From: [Kerren Ven](#)
To: "Rebecka Groth"
Subject: RE: Jalco Manufacturing Facility(SSD-21190804)- Reminder of Due Date for Response to Planner
Date: Monday, 21 March 2022 11:38:38 AM
Attachments: [image009.png](#)
[image002.png](#)
[image006.png](#)
[image008.png](#)
[image010.png](#)
[image012.jpg](#)
[image014.jpg](#)
[image016.jpg](#)
[image018.png](#)
[image019.png](#)

Council's officers have reviewed the applicants response to submissions report and supporting technical studies . The following information shall be provided for further consideration of the proposal:

Figure 14 Odour Impacts

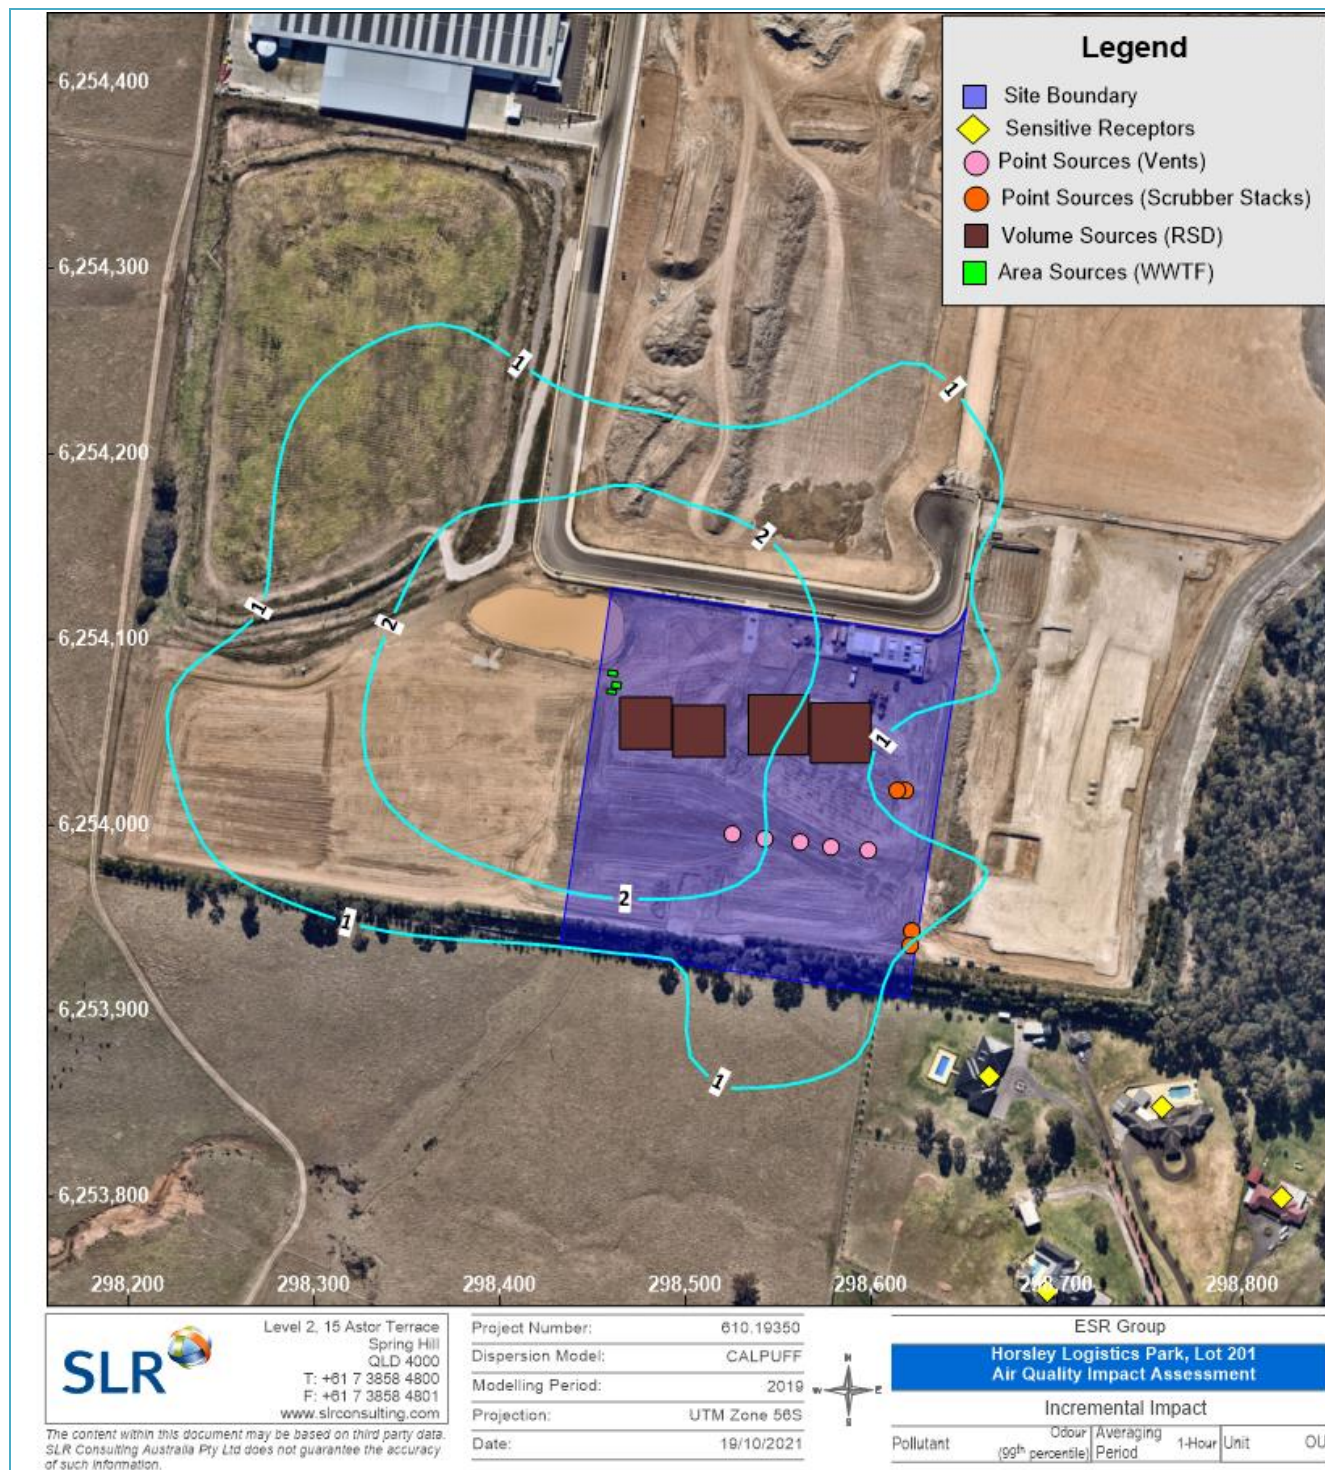
- Table 11 Predicted Odour concentrations at Residential Receptors and Figure 14 Odour Impacts, present within the report demonstrates the predicted odour impact that identified receivers are to experience. The Table displays that the odour concentration predicted at all surrounding residential receptors are below the relevant odour criteria of 2ou. It is then further indicated that all commercial receptors are predicted to experience odour concentrations (average across the entire commercial site) below the 2ou criterion with the exception of receptor C1 which is predicted to experience an exceedance of 2.8ou which the consultant considers is marginal.

A revised dispersion modelling assessment must include various pollution control strategies until compliance is achieved in accordance with the NSW EPA Approved Methods for Modelling and Assessment of Air Pollutant Guidelines.
